Consultation Response from KC, Highways Development Management
2024/91174 5a, Northumberland Street, Huddersfield, HD1 1RF
Reconfiguration of 6 student bedsit flats to create 16 student apartments (within a Conservation Area)
Date Responded: 05/12/2024 Responding Officer: CNB Responding Ref: K5-7NE/22

BASEMENT FLOOR PLAN

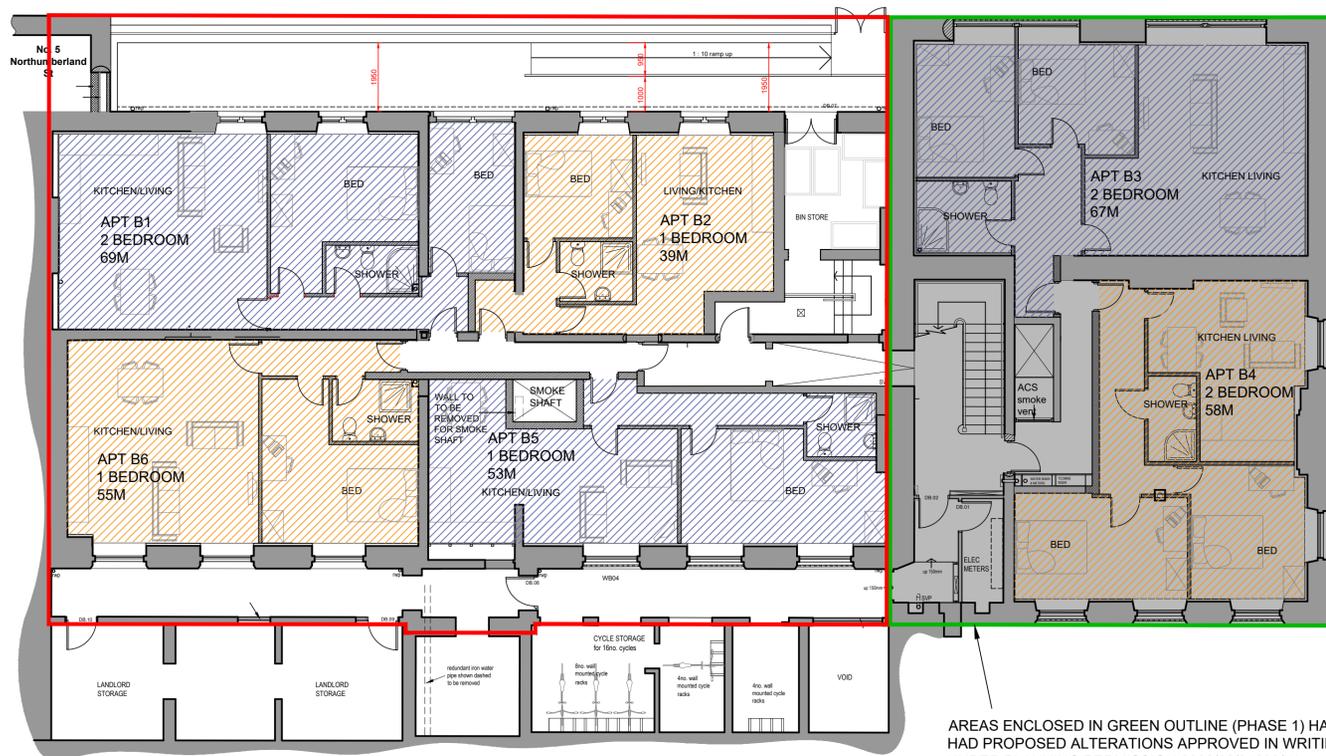
The proposals are for 17 cycle storage spaces within the basement, this appears to be for both phases of the development, a total of 30 apartments. The current local standards for cycle parking are for 1 space per dwelling and so we would like to see this increased to be more in-line with standards. It should also be noted that Drawing No 05 Rev A shows the cycle storage is located within the basement and this would necessitate cycles being carried up and down stairs. Unless the cycle storage can be relocated to a more suitable location then we would wish to see cycle gutters adding to the stairs on the route between the cycle store and the main entrance. Details of the type of cycle rack should also be provided to ensure the provision will provide secure storage that reduces the possibility of either theft or damage to cycles. This can be conditioned.

Waste storage is shown on drawing No 05 Rev A to the rear of the site within the basement. The waste storage area has a ramped exit out on to the back street between Byram Street and Lord Street and it should be noted that this adopted road may be included within the Huddersfield Market Improvements scheme. Colleagues in the Kirklees Waste Strategy team have indicated that a waste collection already occurs from the premises, and this would be expected to continue and so this is considered acceptable.

Before first occupation, details of suitable cycle storage and access facilities shall be submitted to and approved in writing by the Local Planning Authority. The approved details shall be provided before first occupation and shall be so retained thereafter.
